Reference:	H21-1136-23	Date of Decision:	14th May 2024
Applicant:	Mr S Necker 23 Popes Lane Leverington Wisbech PE13 5BD		
Location:	Land North Of 29 Station Road Tydd Gote Wisbech		
Description:	Proposed holiday lodges and yoga building

South Holland District Council hereby give notice that this application has been REFUSED for the above proposal for the following reason(s):

SITE PLAN 1:500

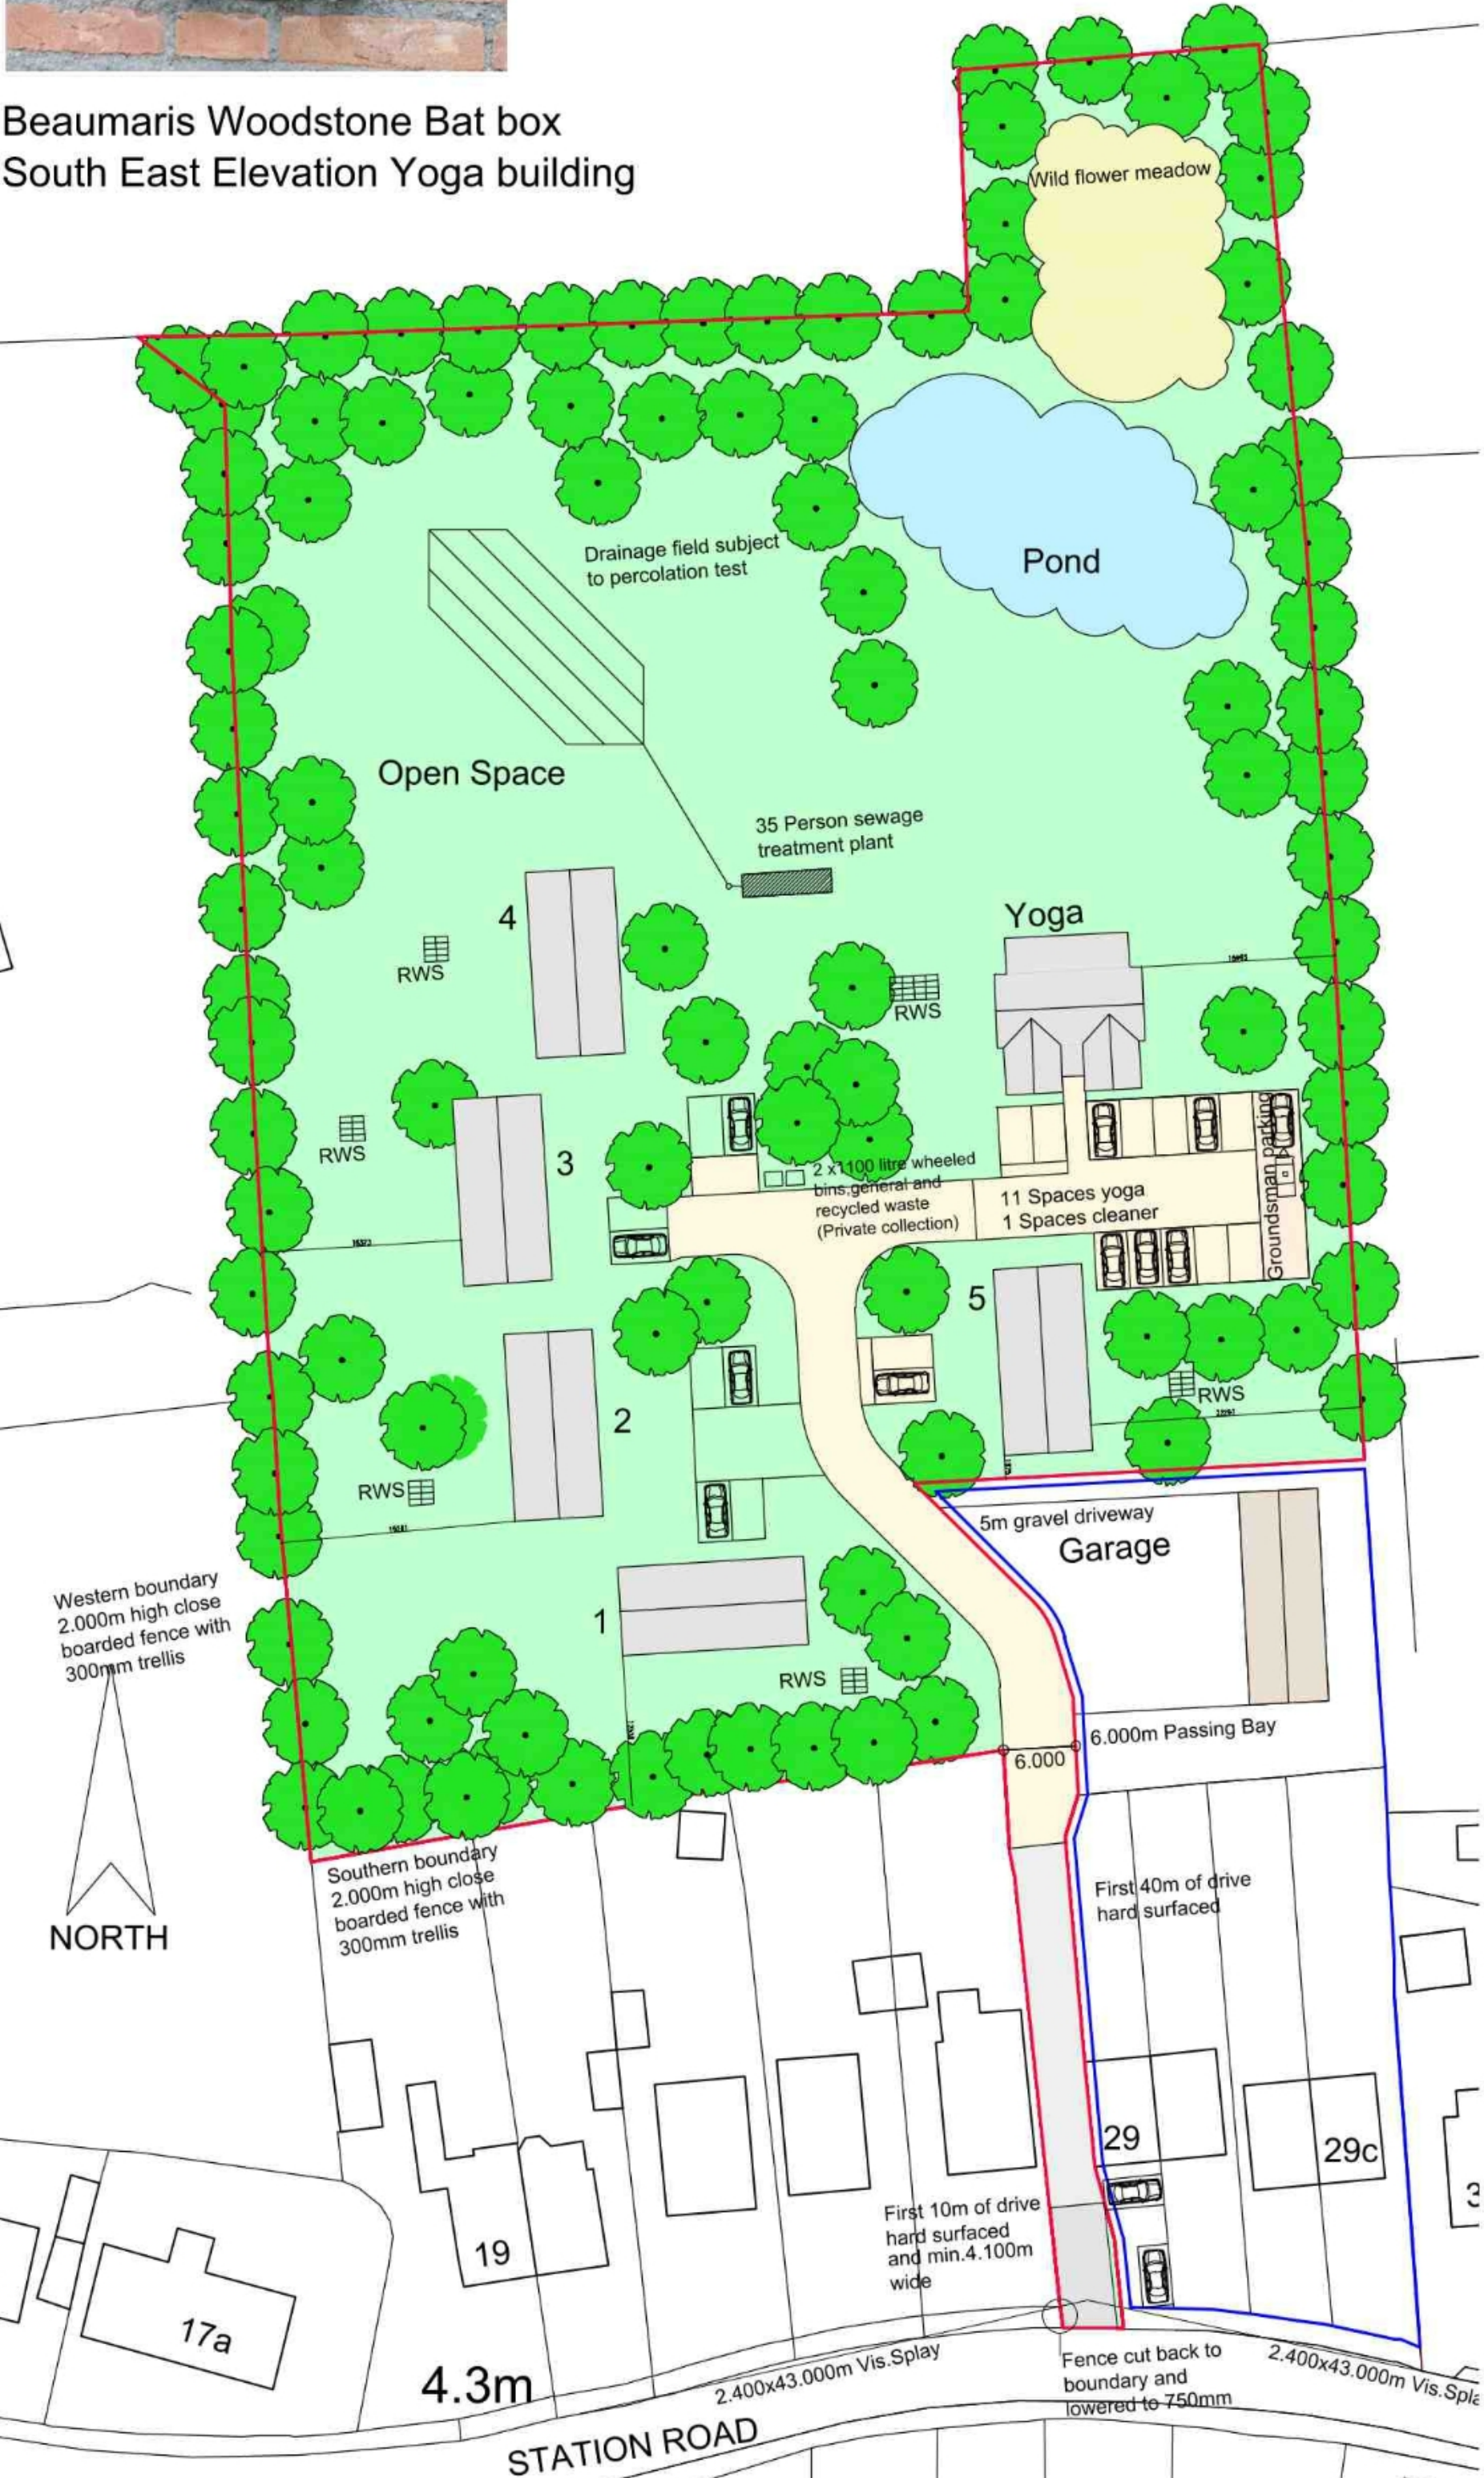
- 1 In the opinion of the Local Planning Authority the activity associated with the proposed development and especially vehicles passing along and manoeuvring within the narrow access to the site would have an unacceptable and materially adverse impact upon the amenity of neighbouring residents in terms of noise and general disturbance.

Moreover, the narrow access point, which is heavily constrained by fencing and a telegraph pole, would be likely to lead to vehicles backing up into Station Road causing a nuisance and holding up passing traffic and would increase the noise and disturbance of vehicle movements in the immediate vicinity of the site.
